The Drovers Solar Farm

Statement of Common Ground (SoCG) with Borough Council of King's Lynn and West Norfolk

PINS reference: EN0110013

Document reference: APP/5.20 (Original)

## **Figure 6.15: PM8, PM12 and PM14 Summer Photomontages - Illustrative Scheme (Part B)**

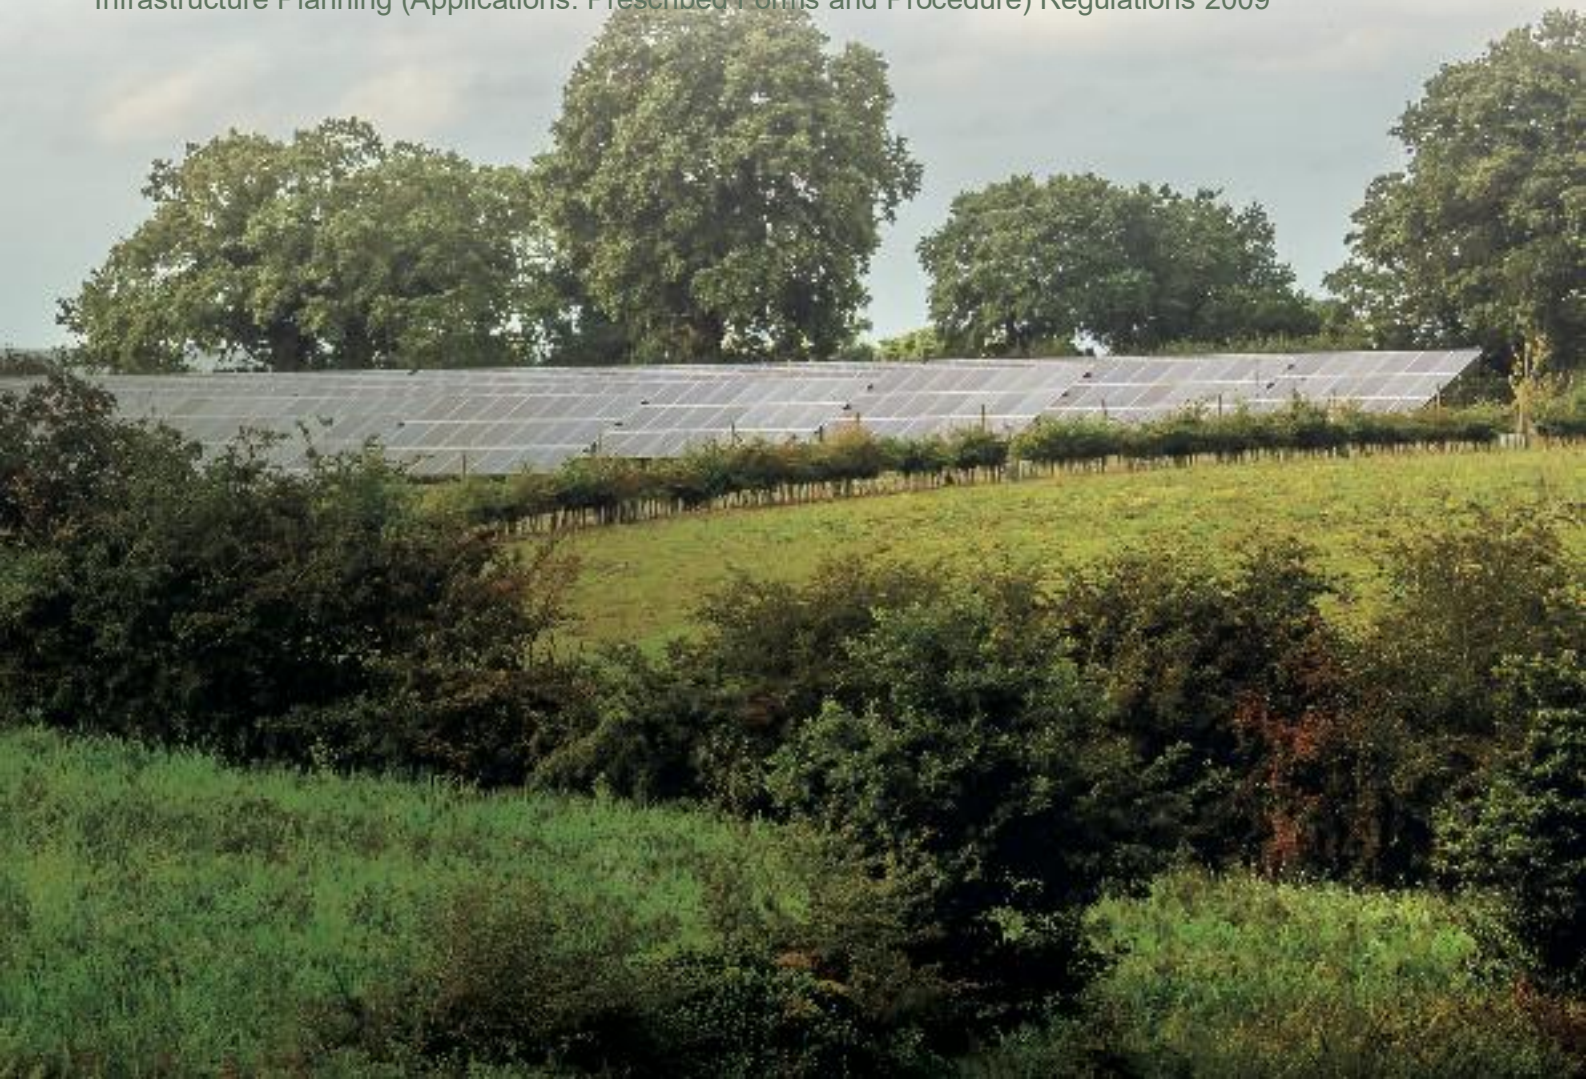
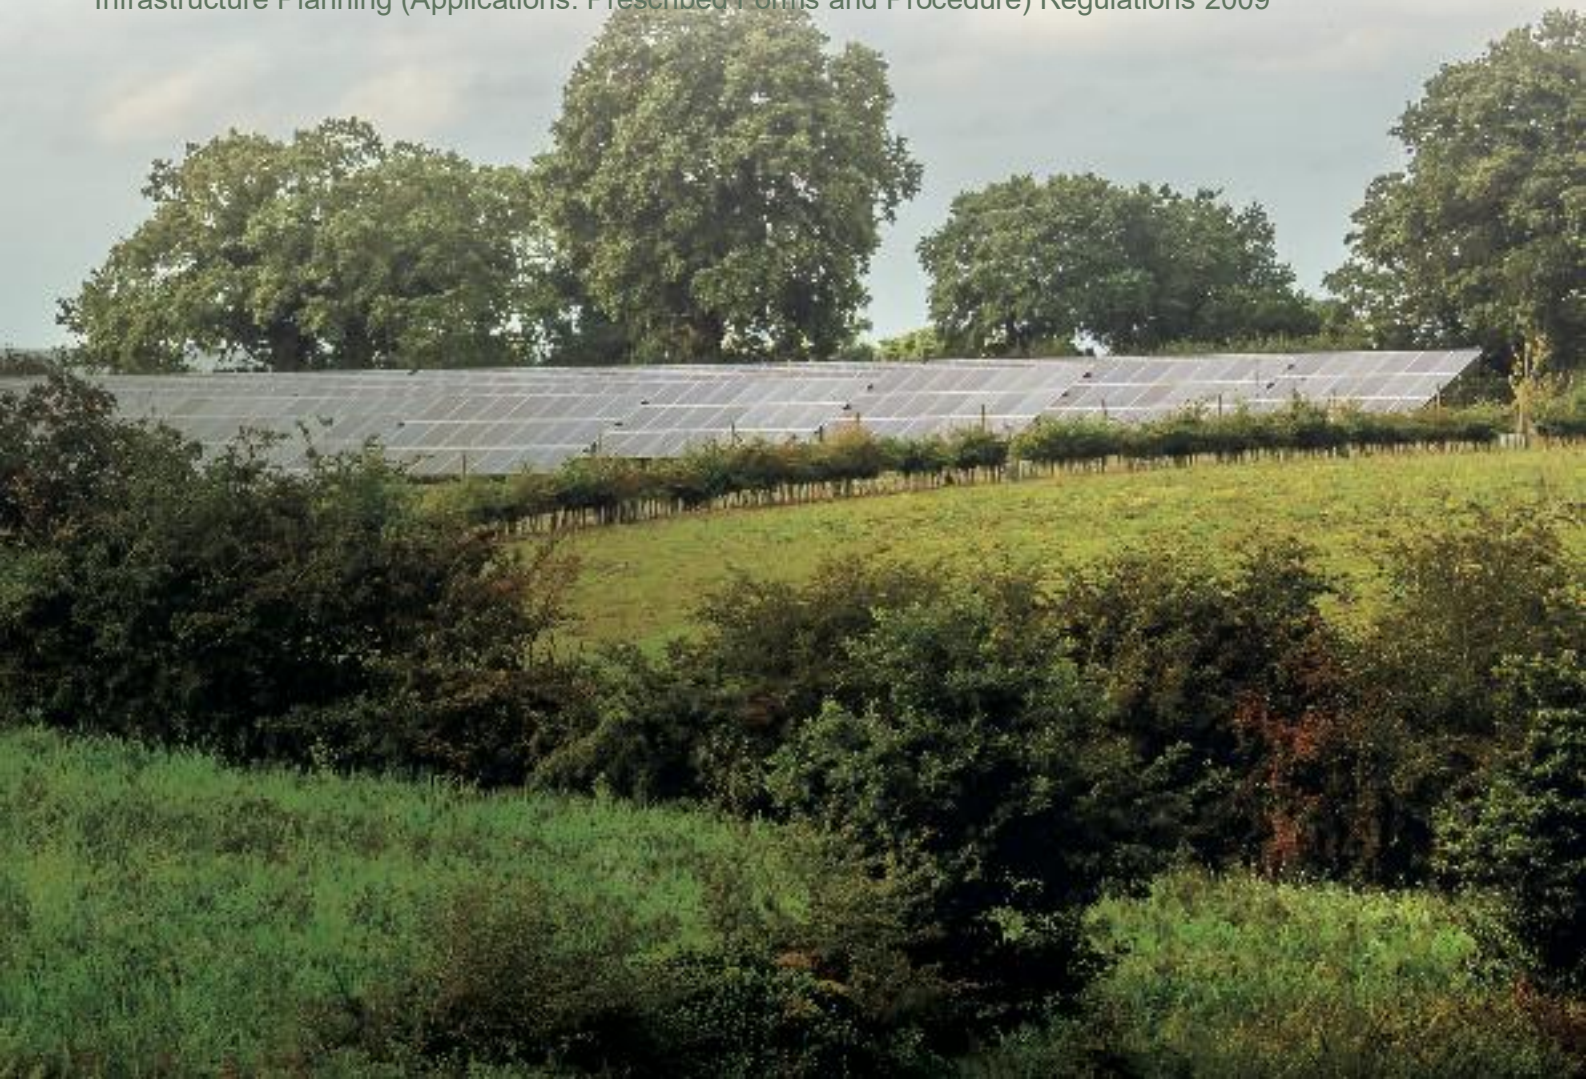
KLWN 1-2	Key Views	The Applicant has worked with the Borough Council's planning and heritage teams to reduce harm as much as possible. Moving the substations out of direct view from Castle Acre and placing them south of Bartholomew's Hill Plantation would not eliminate harm but would filter views and lessen visual impact. Removing solar PV from the northern part of field 33 is also positive, as the topography means the remaining panels would sit beyond the crest and be barely visible.	There is no anticipated substantial harm to, or total loss of, any designated heritage assets' significance as a result of the Scheme. ES Chapter 8: Cultural Heritage and Archaeology [APP-057] outlines that 'substantial harm' is afforded to any adverse effect that is of a major magnitude, whilst moderate, minor or negligible adverse effects represent effects that are of 'less than substantial harm' in nature. As detailed in the submitted visualisations (ES Figure 6.14: PM8, PM12 and PM14 Winter Photomontages - Illustrative Scheme [AS-039] and ES Figure 6.15: PM8, PM12 and PM14 Summer Photomontages - Illustrative Scheme [AS-045]), the National Grid	Medium

Substation and the Customer Substation will be entirely screened by Bartholemew's Plantation in views from the north, thereby removing, rather than reducing, visual impact. As described in ES Chapter 8: Cultural Heritage and Archaeology [APP-057] , new pylons will be visible, but not other elements of the National Grid Substation and the Customer Substation.	
--	--	--	---	--
